**BYERS GILL SOLAR
DARLINGTON BOROUGH COUNCIL
IP reference number BGSF-AFP412**

**Post-hearing submission of oral case of Stephen Laws, Glenkemp Landscape Architects on
behalf of Darlington Borough Council**

**Issue Specific Hearing 7 (ISH7) on Environmental Matters (Cumulative Effects)
Wednesday 27 November 2024**

Drawing Title
**Figure 7.6.1
 Key Settlements: Brafferton**

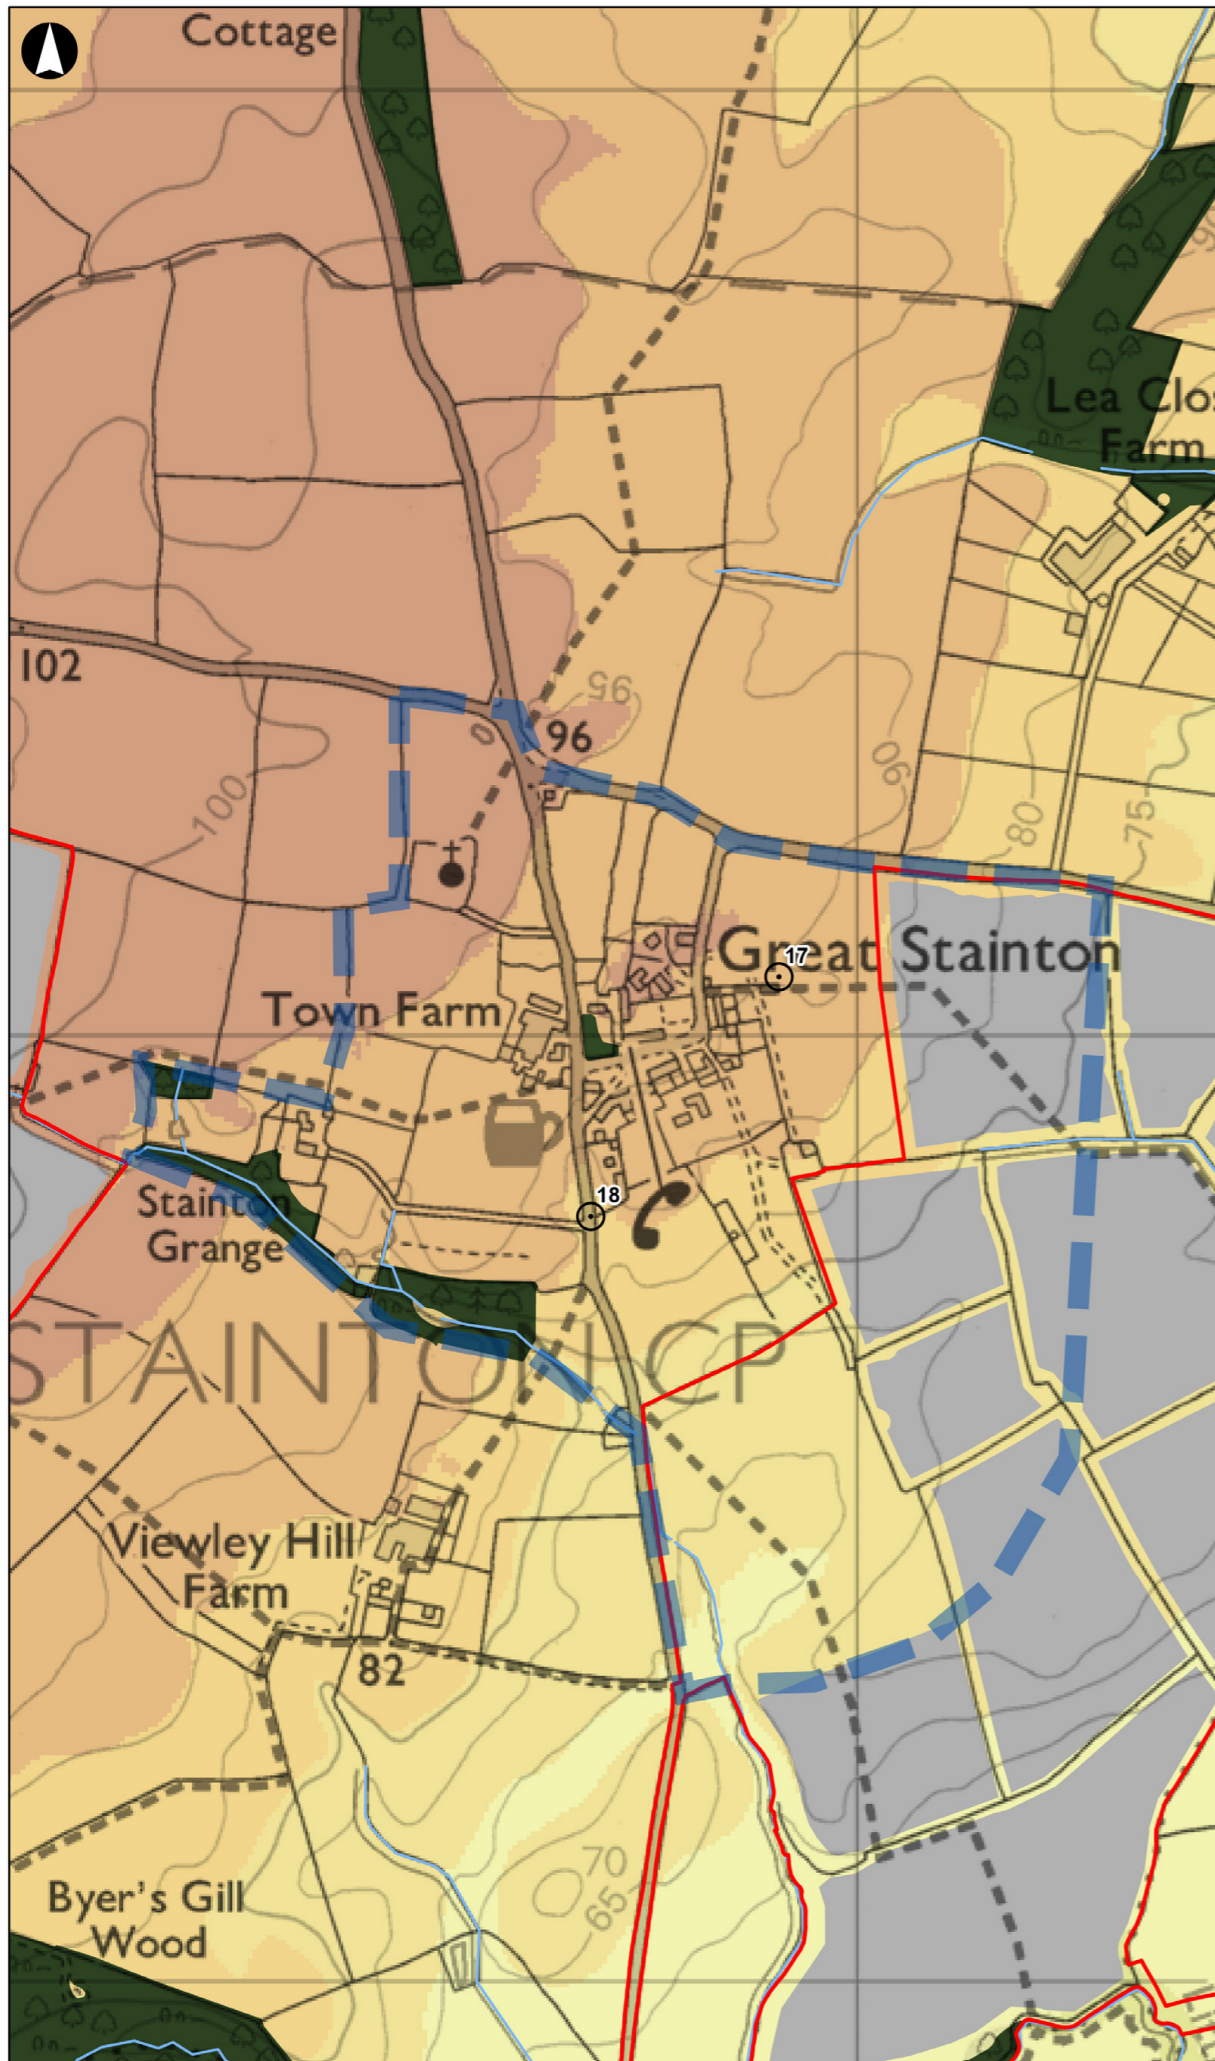
DBC is of the opinion that the potential impact of cumulative effects on Brafferton, due to Whinfield Solar Farm, is not fully assessed in the ES due to the limited extent of the setting shown in ES Figure 7.6.1 and also the omission of any assessment of visual effects generated by this cumulative development on receptors located within the setting.
